From: Rich Elliott <elliotttr@kvfr.org>
Sent: Saturday, March 15, 2014 12:59 PM
To: Jeff Watson; Lindsey Ozbolt
Cc: Joe Seemiller; John Sinclair; Brenda Larsen
Subject: RE: Kittitas County Notice of Application CU-13-00008 Helena Substation

CU-13-00008 Helena Substation

**A3**

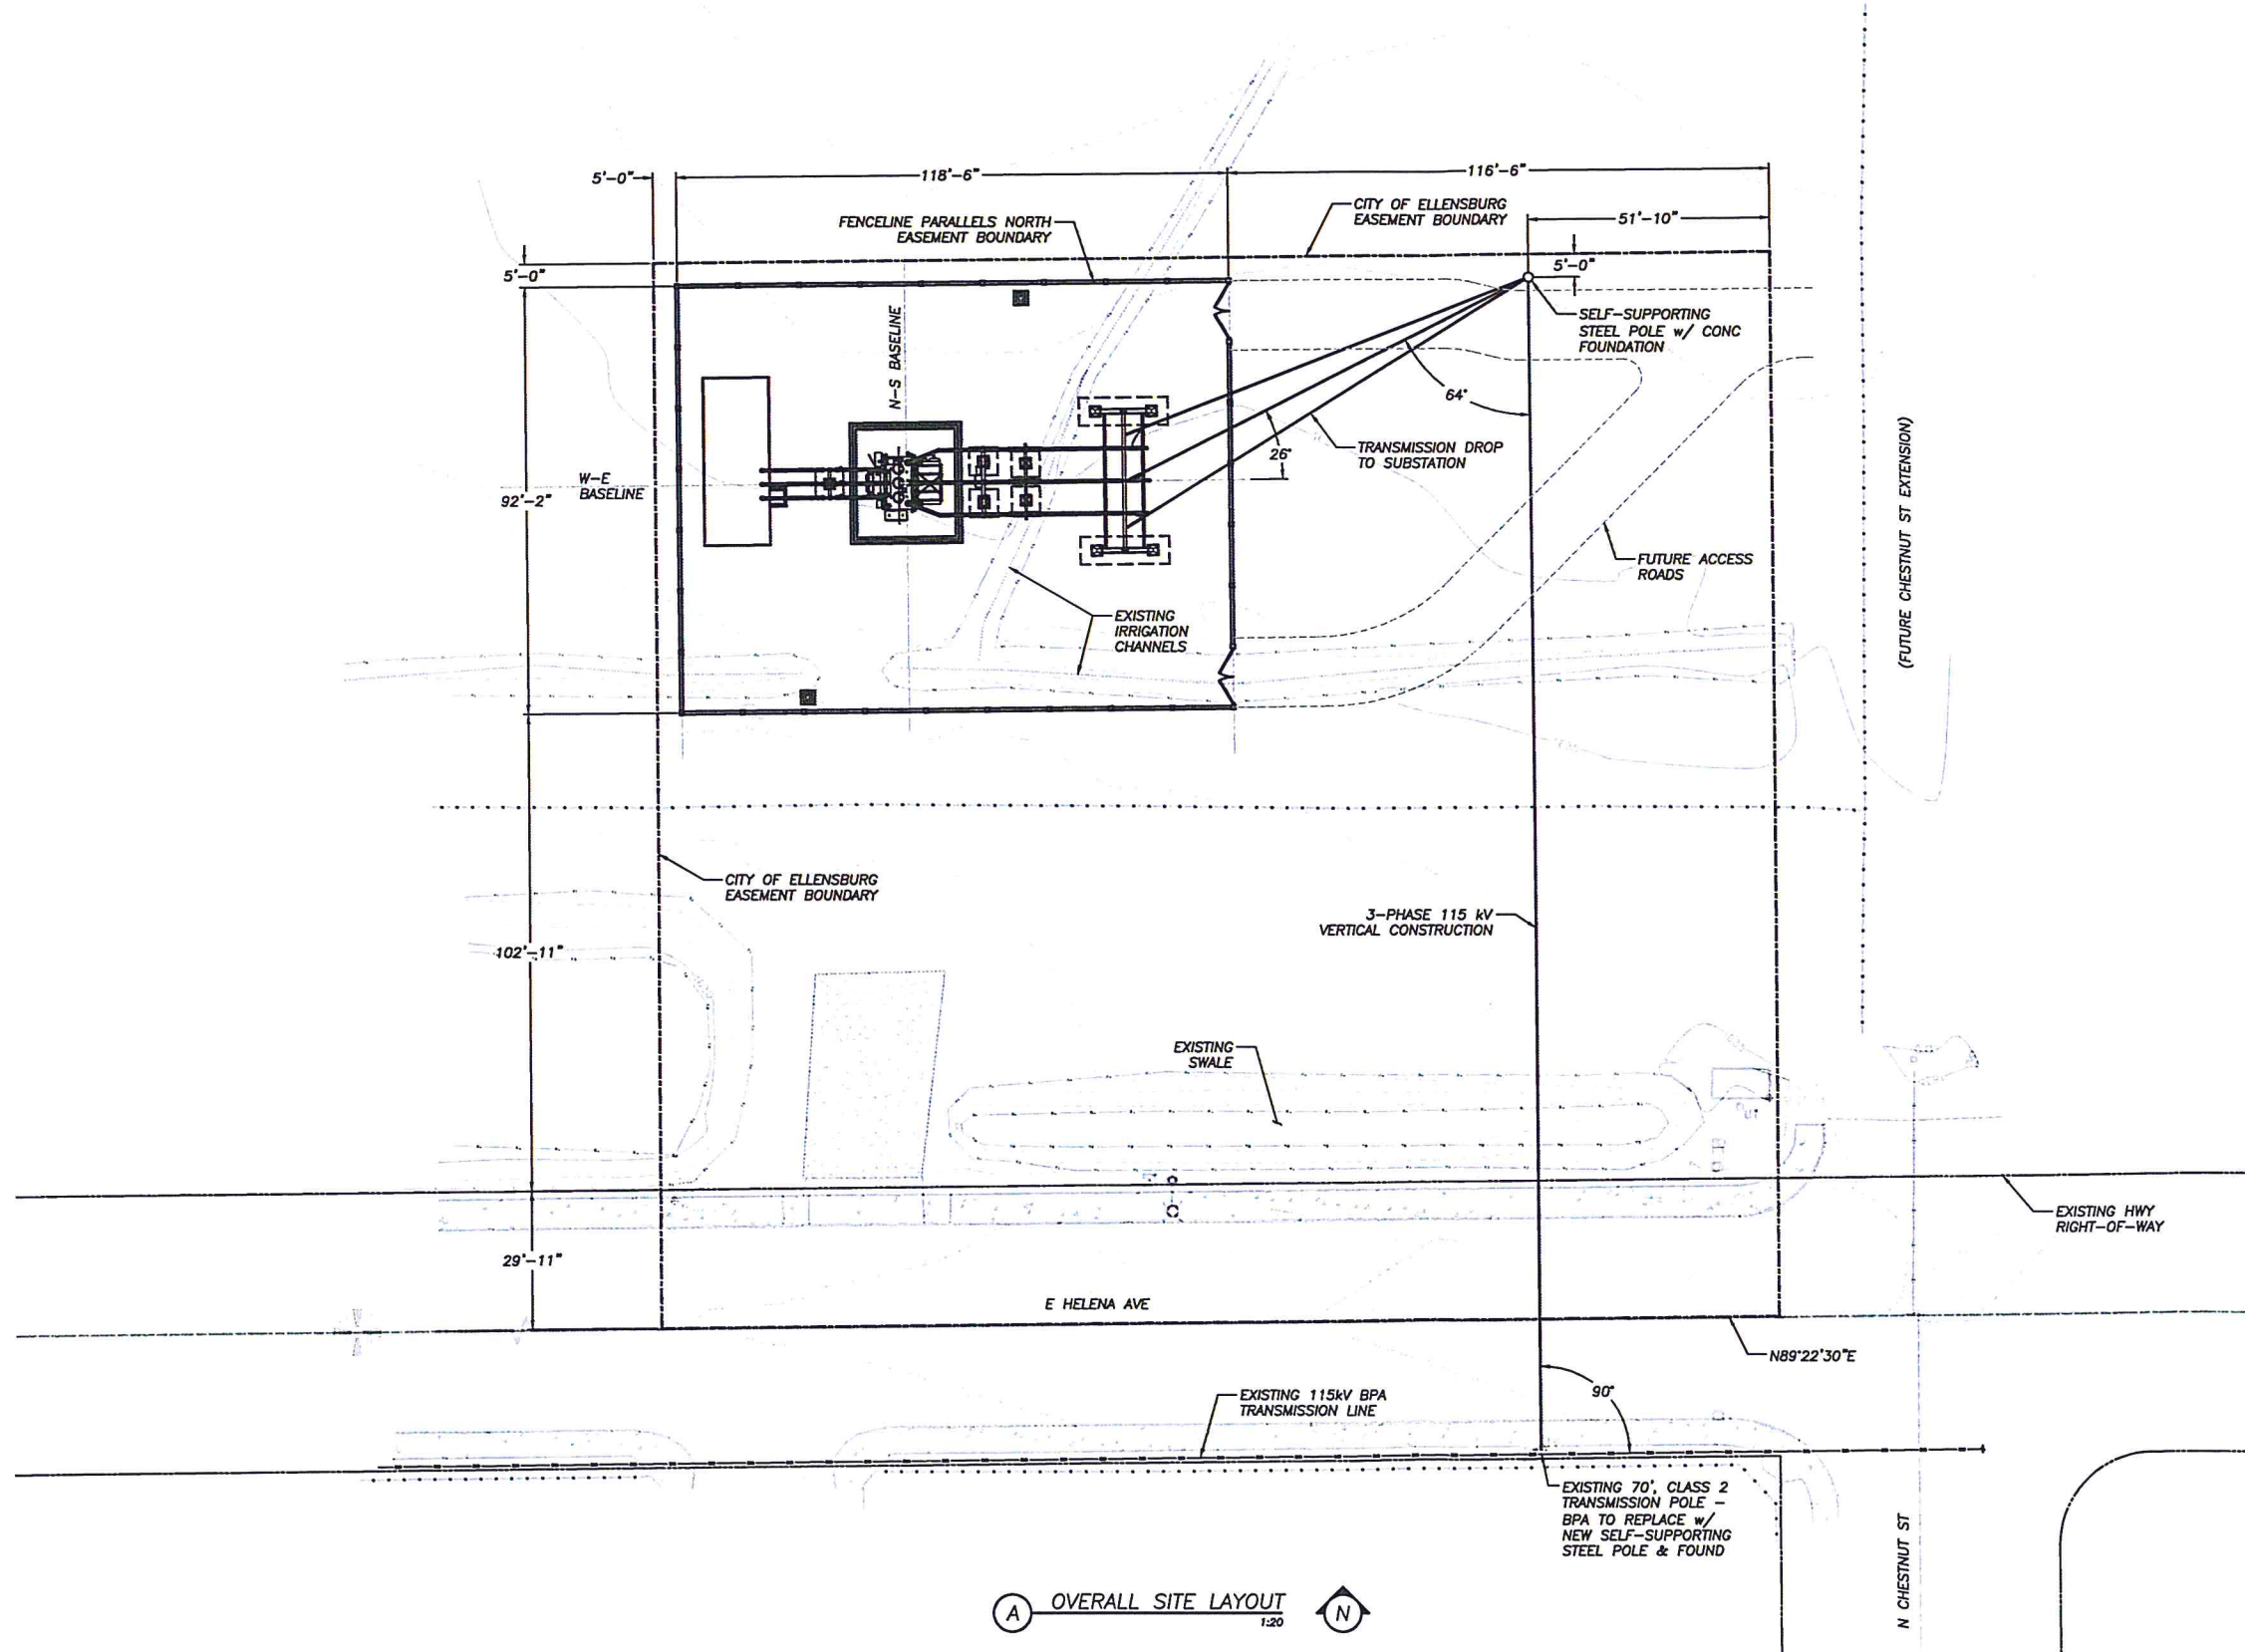
1. The property will be addressed according to Kittitas County Code with the address clearly visible from both directions of travel.
2. The property owner will provide KVFR with a site specific plan on mitigation of electrical hazards on the property.
3. Access to comply with Appendix D of the current IFC.
